# CITY OF ALBUQUERQUE

March 27, 2014

**Re: GAHH Relocation and Tenant Improvements, 4900 Menaul Blvd NE  
Temporary Certificate of Occupancy Extension – Transportation  
Development (H17-D110)**

No.	Description	Date
20_1225	CAD DWG FILE: DWL-NM_RESTORE	
	DRAWN BY: B. RAEL	
	CHECKED BY: R. BURTON	
	SHEET TITLE: TRAFFIC CIRCULATION PLAN

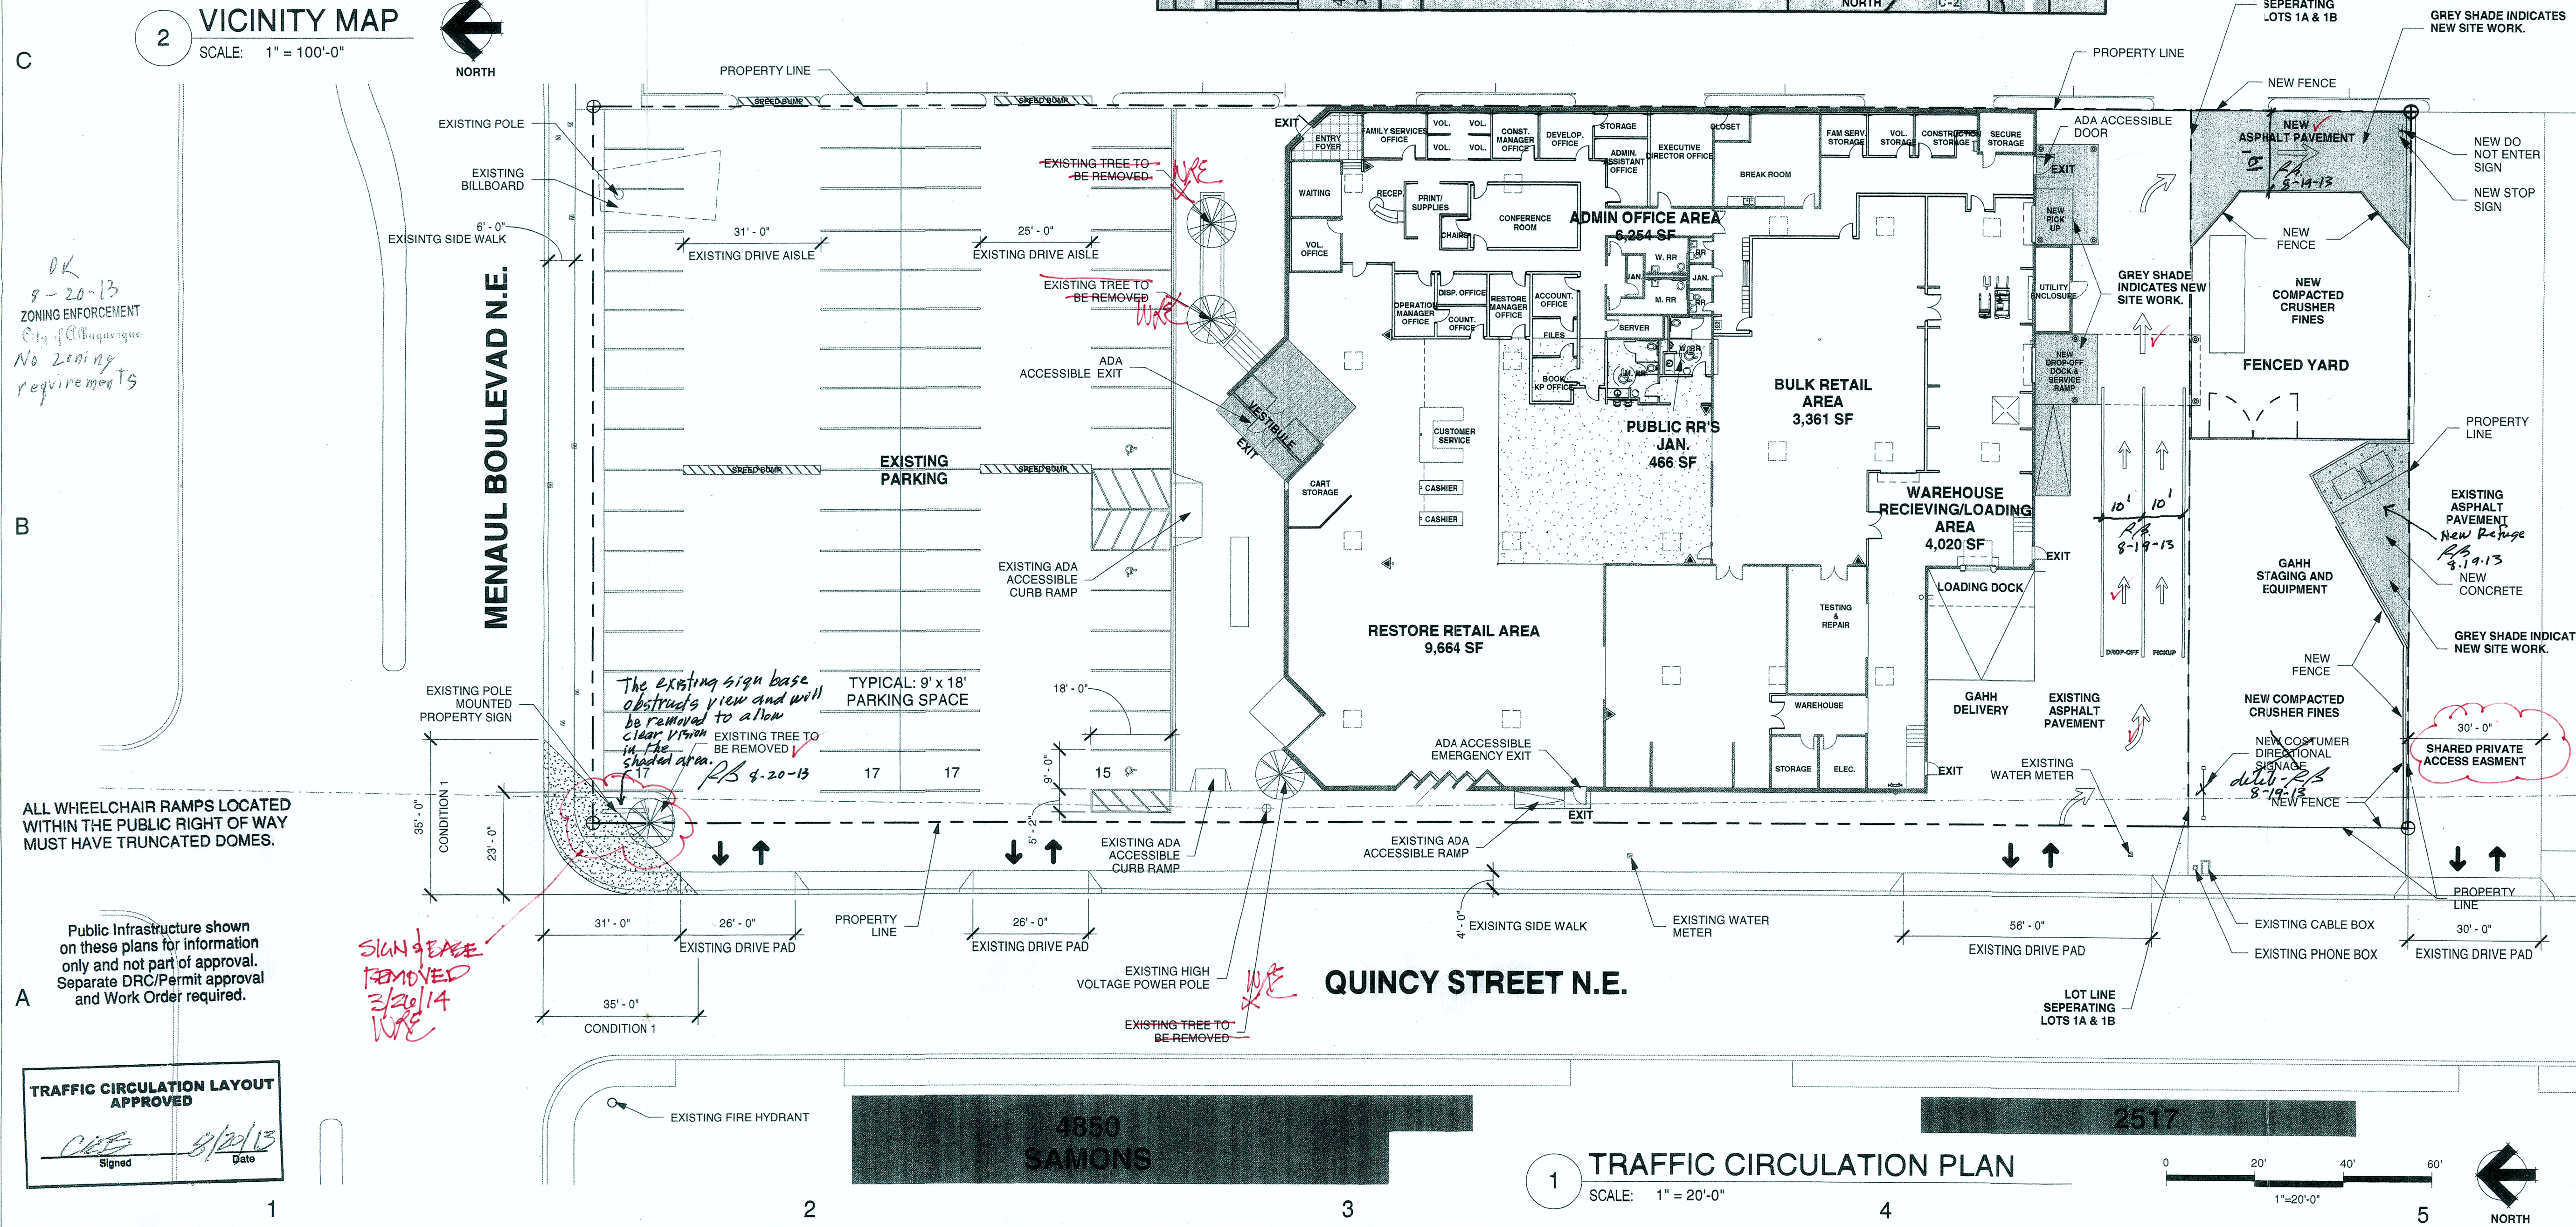
- The existing sign located at the corner of Menaul and Quincy, including the pedestal, must be removed.
- Signing and striping of the drop off area south of the building must be completed. At this time, compacted crusher fines and/or base course may be used to tie into the existing 30-foot wide shared access easement, with the understanding that asphalt pavement will be placed at a later date.
- Encroachments into the City of Albuquerque right of way will be addressed (see email dated 11-07-13 for additional information).
- A full certification including the approved plan with all appropriate red-lines, must be provided for permanent certificate of occupancy.
